Response to Planning application from Hertfordshire County Council (T and CP GDP Order 2015)

District ref: 6/2023/1433/COND
HCC ref: WH/17534/2023
HCC received: 14 July 2023
Area manager: Manjinder Sehmi
Case officer: Chris Carr

Salisbury Square Hatfield AL9 5AD

Submission of details pursuant of condition 2 (construction management plan) on planning permission 6/2021/3422/MAJ

Drawing No  
**221111-CON-XX-00-DR-C-6000**

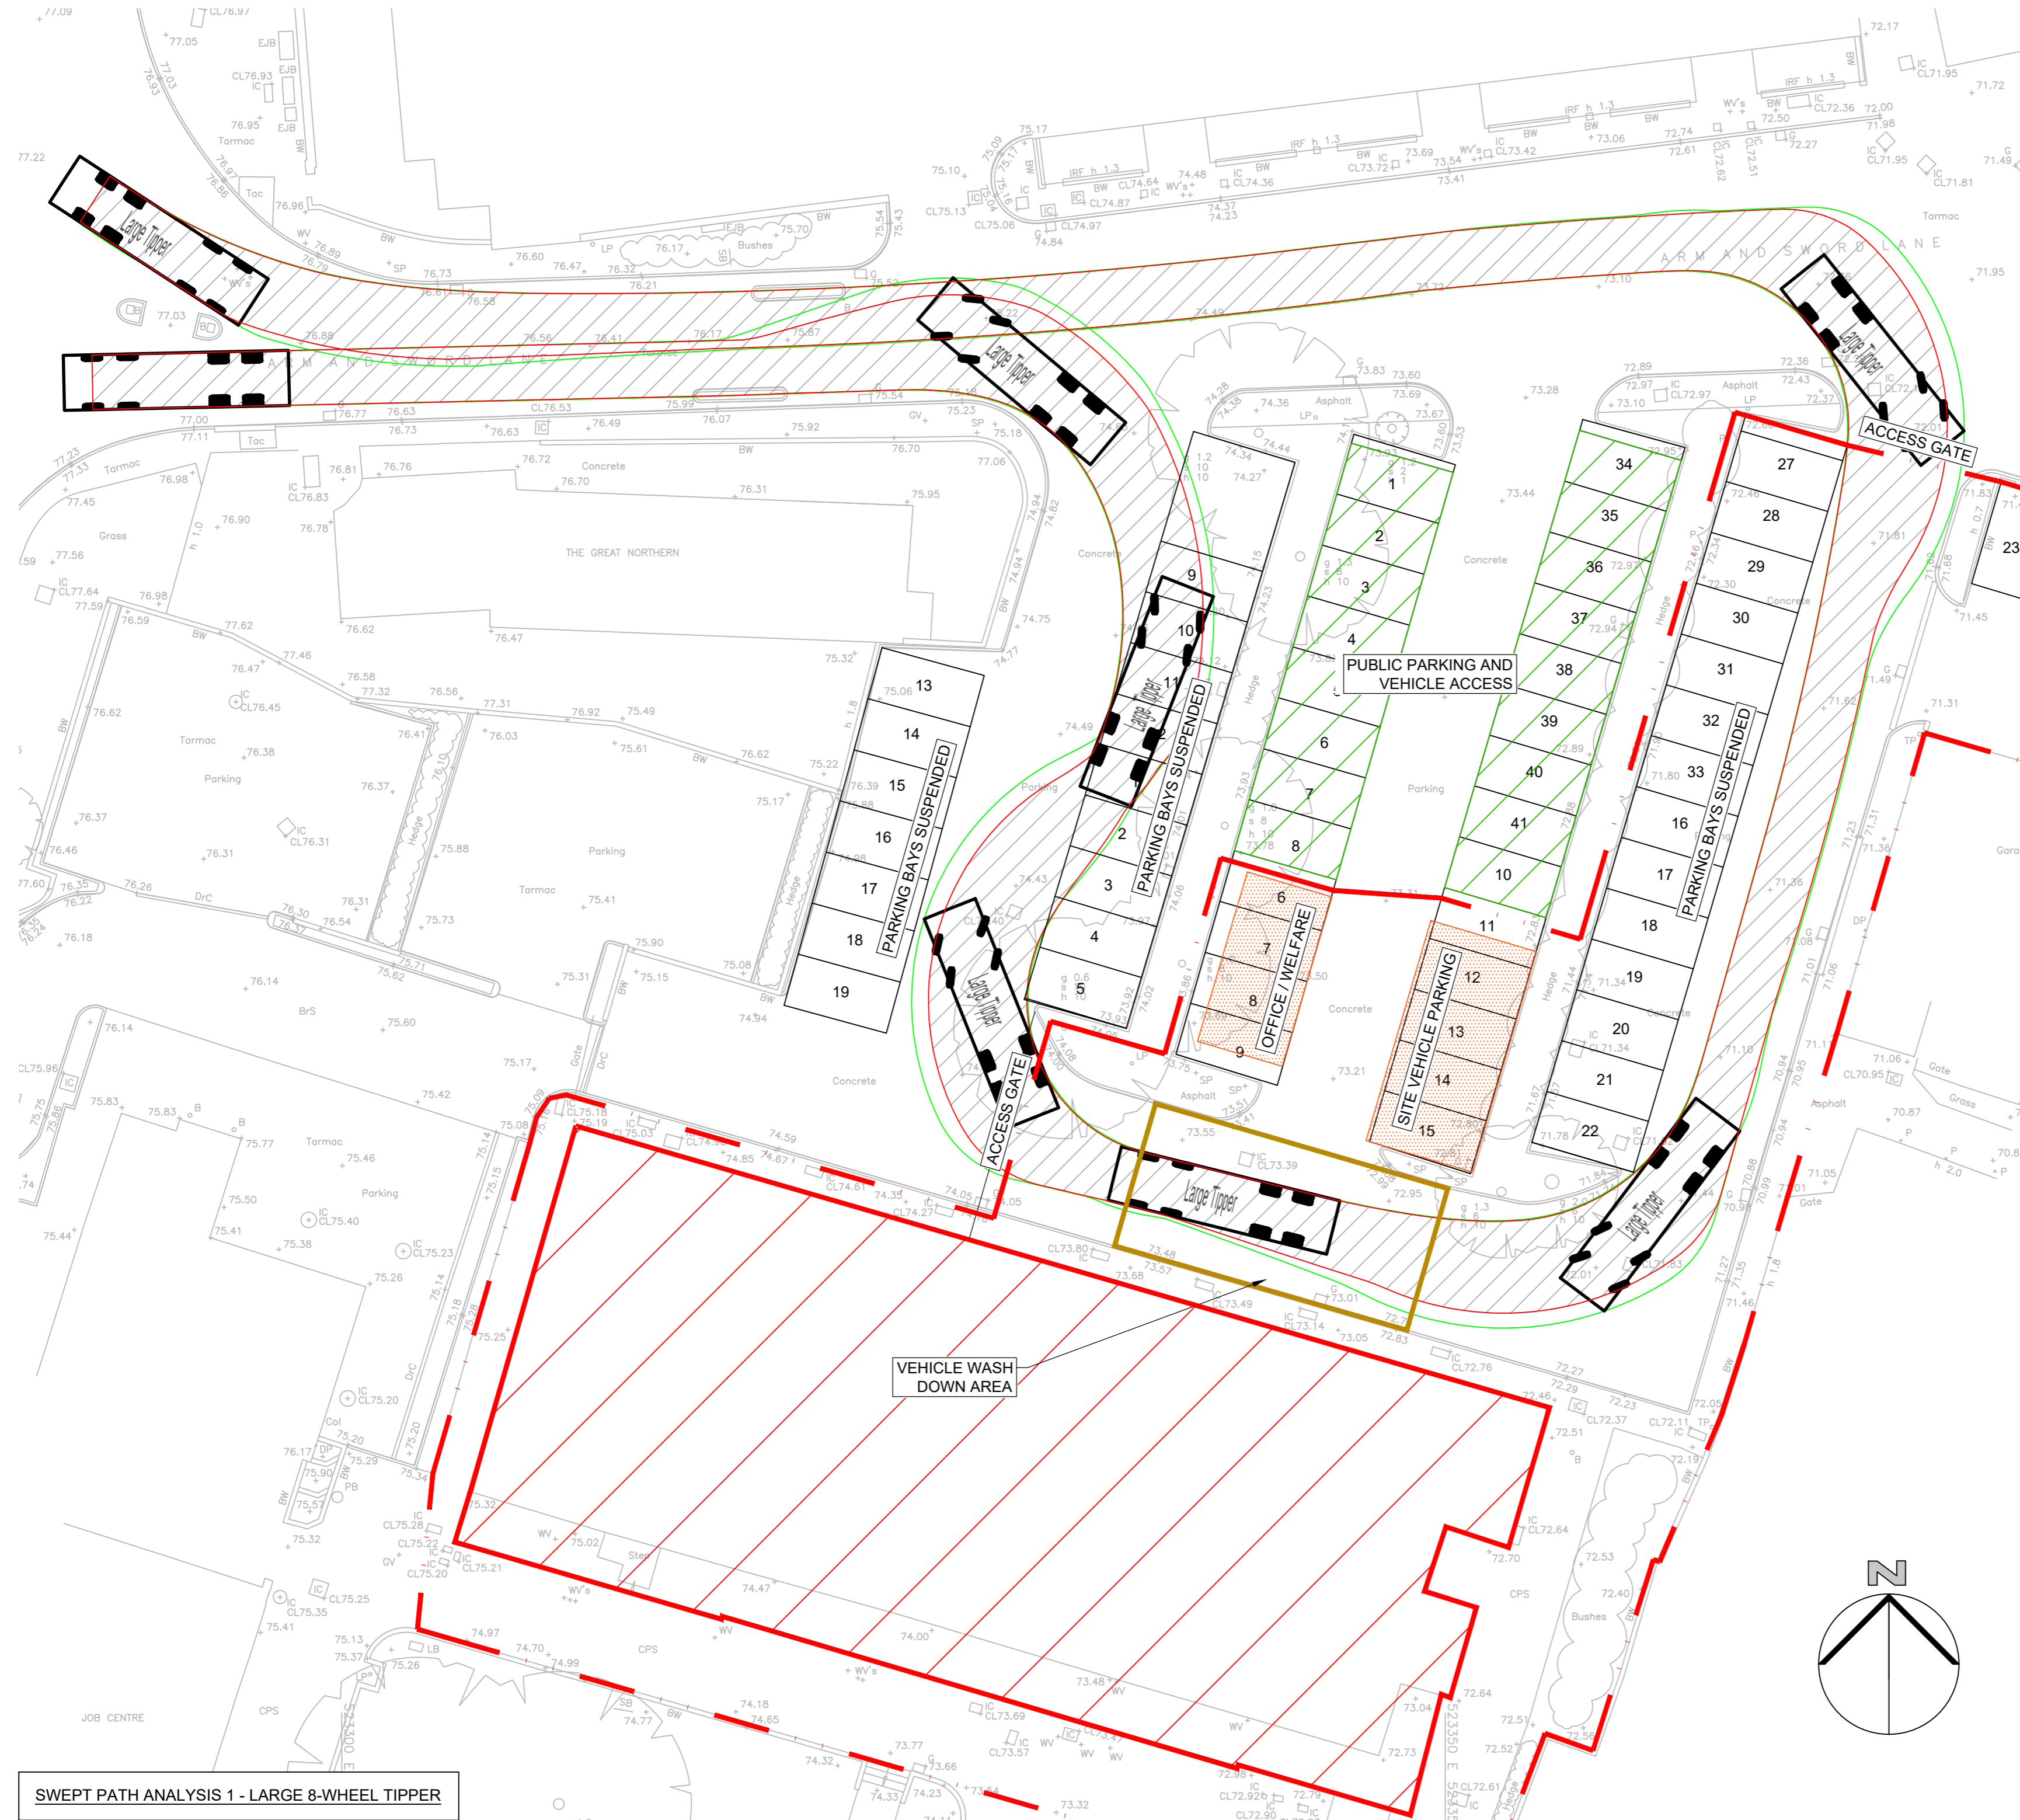
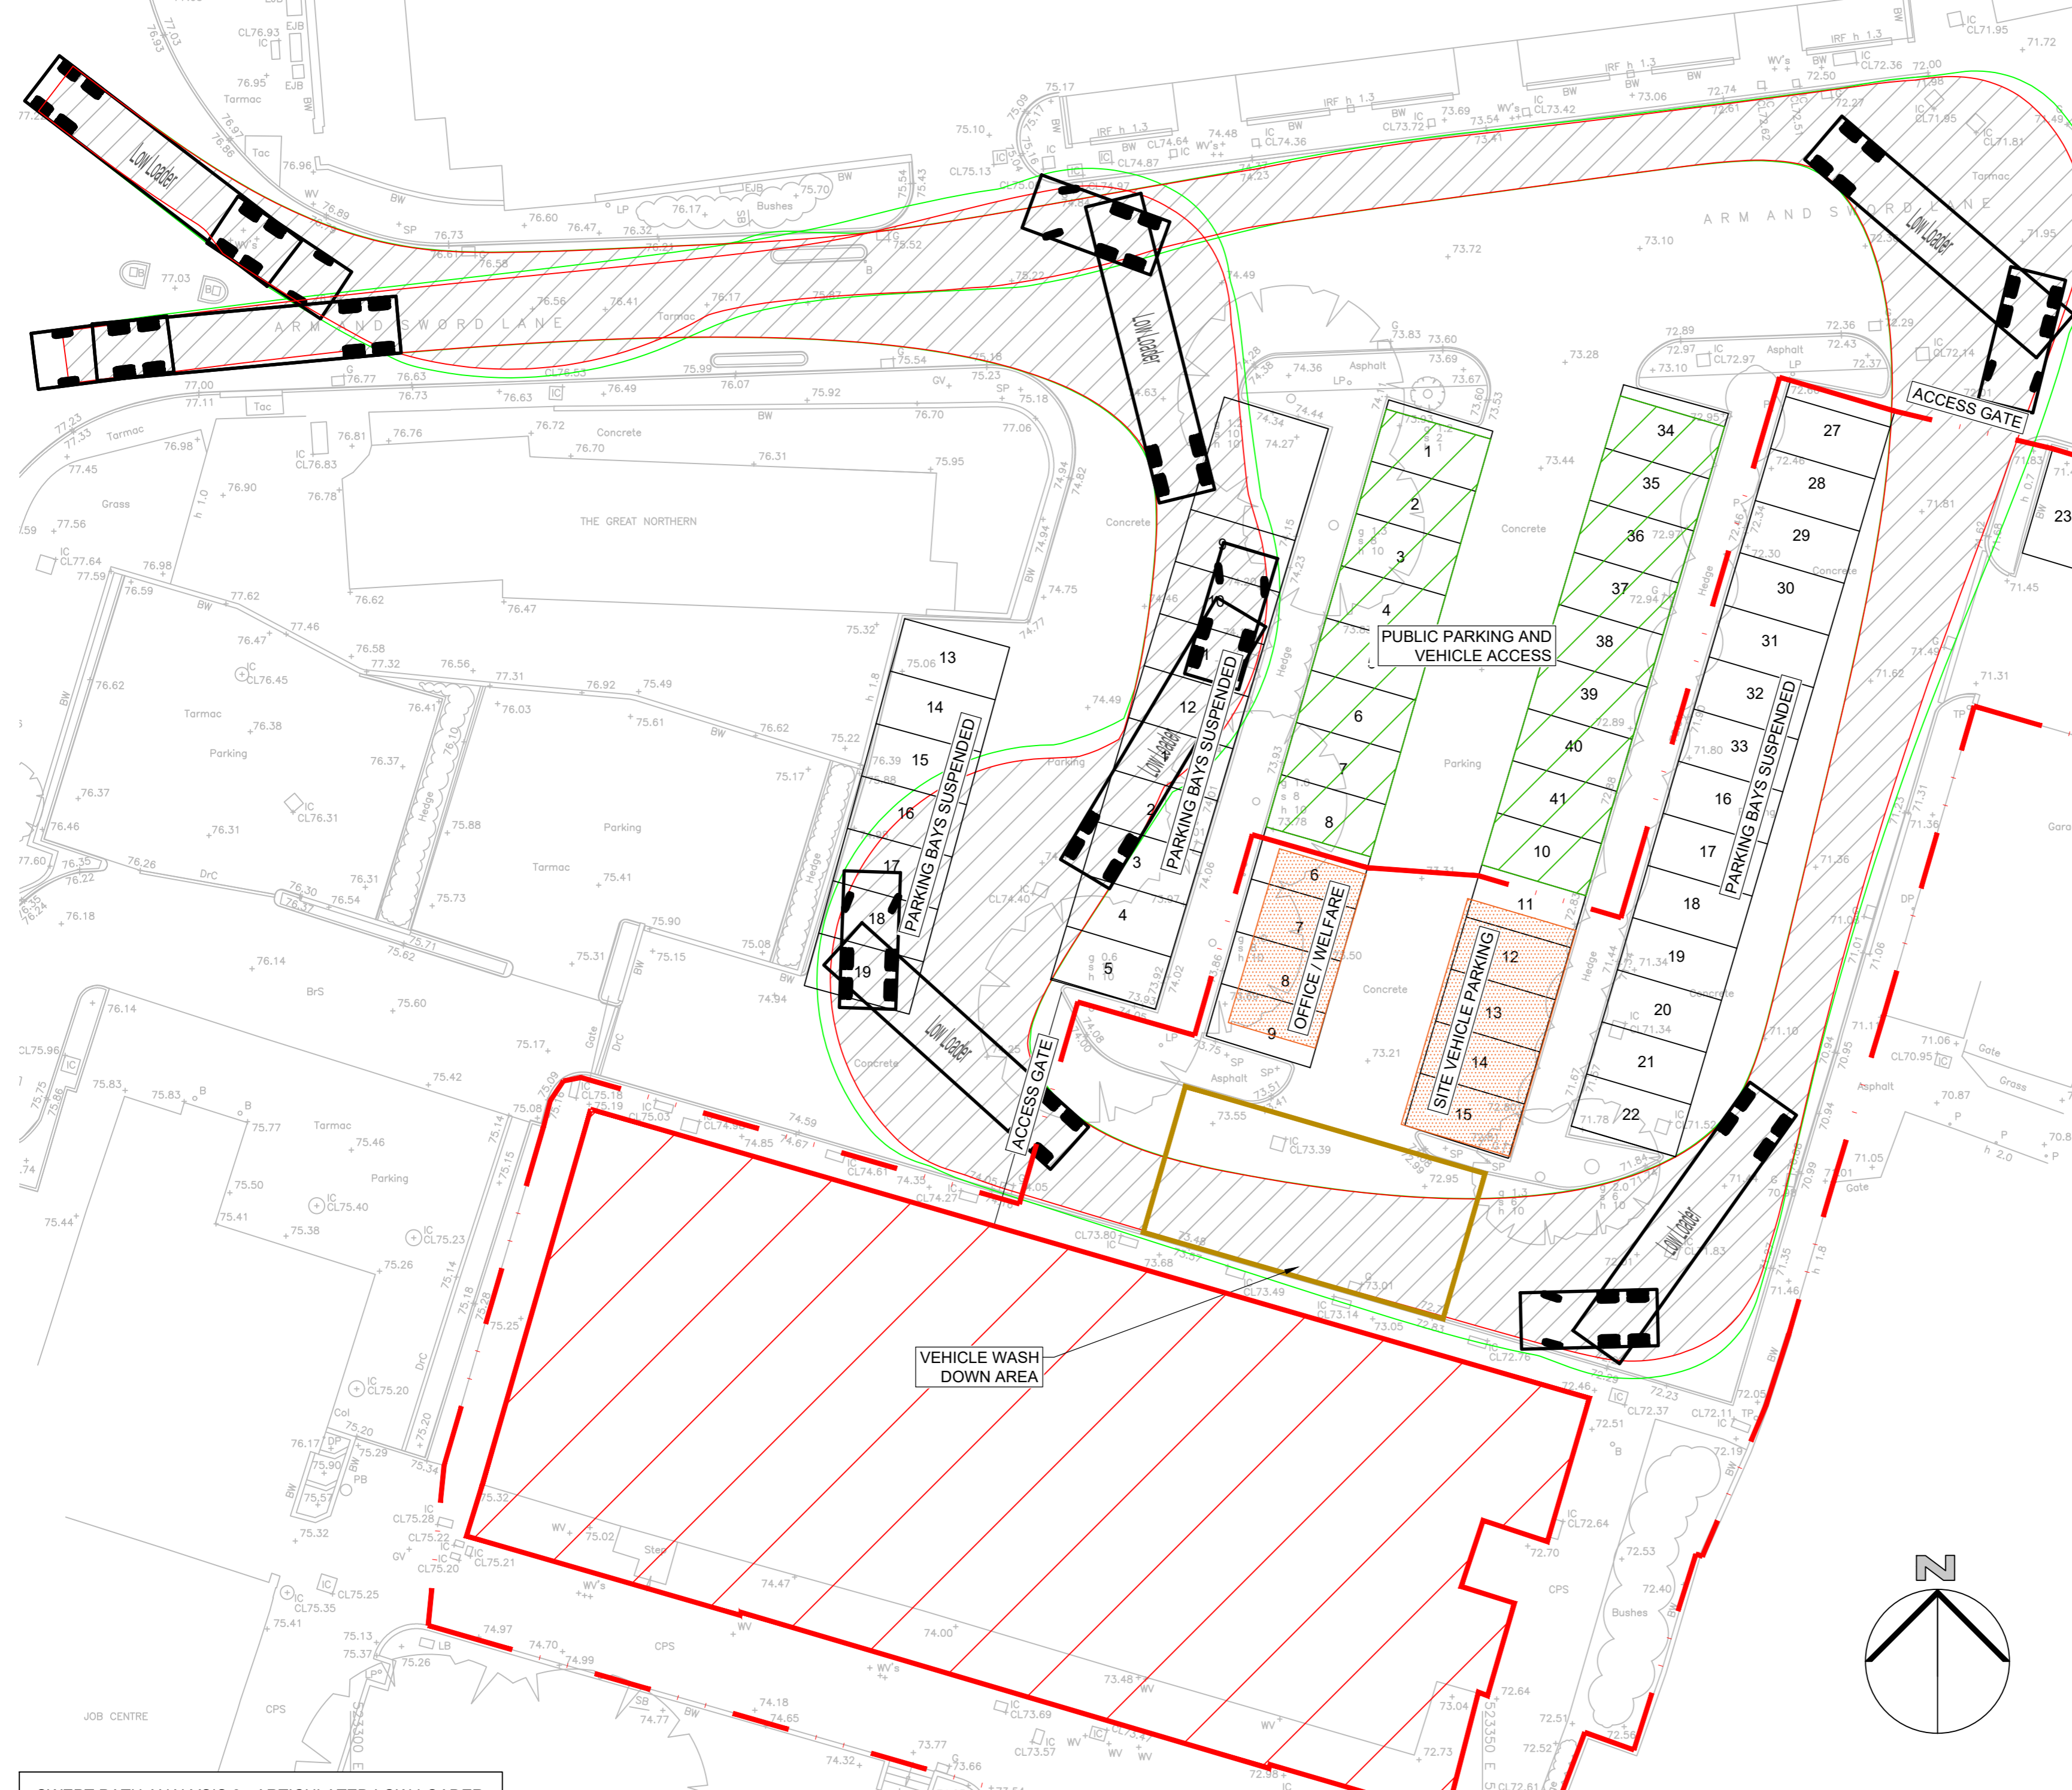
a) The CMP includes details of the expected vehicle numbers and types of vehicle. The largest vehicle expected is a 16.15m long low loader. The applicant has submitted swept path analysis (drawing 221111-CON-XX-00-DR-C-6000-P02) showing a large tipper (10.2m long) and a long low loader (16.15m long) entering and exiting the construction site in forward gear. Directly opposite the construction access is existing on-street parking along Arm and Sword Lane. The swept path analysis shows that the long low loader vehicle would only be able to access and exit the site if these existing parking spaces were unoccupied. There are no details provided in the CMP with regards to whether these parking bays would be temporarily suspended. Therefore it is assumed that based on this existing parking, the proposed construction vehicles would not be able to enter and exit the site. Therefore updated swept path analysis is required.

b) During construction, it is proposed that vehicle access will be via Arm and Sword Lane at the rear of the site. As previously mentioned, the swept path analysis provided is unacceptable as access for the largest vehicle is restricted by existing on-street parking. This therefore needs to be updated. The CTP confirms that Banksman will be posted at the site entrance to protect pedestrians or warn approaching traffic whilst marshalling wagons or delivery vehicles on/off the site. This is considered acceptable. Pedestrian access to Salisbury Square public realm is immediately adjacent to the west and east of the parade. It is proposed that there would be disruption only to the access route through the car park to Horse and Groom Pub and this will be reinstated at completion of the works.

d) Submitted drawing 221111-CON-XX-00-DR-C-6000-P02 shows the location of 4 site vehicle parking spaces. There are no details of the proposed construction and storage compounds on this drawing however the CMP states that a figure within the CMP demonstrates the currently proposed site set up, including provision of storage / access arrangements for pedestrians & vehicles / temporary accommodation units / wheel washing facilities/phasing and parking area. This figure is not included within the CMP and this is required.
Conclusion: Condition 2 (part d) cannot be discharged at this time.

e) Submitted drawing 221111-CON-XX-00-DR-C-6000-P02 shows the location of the proposed vehicle wash down area and this is acceptable.
Conclusion: Condition 2 (part e) can be discharged.
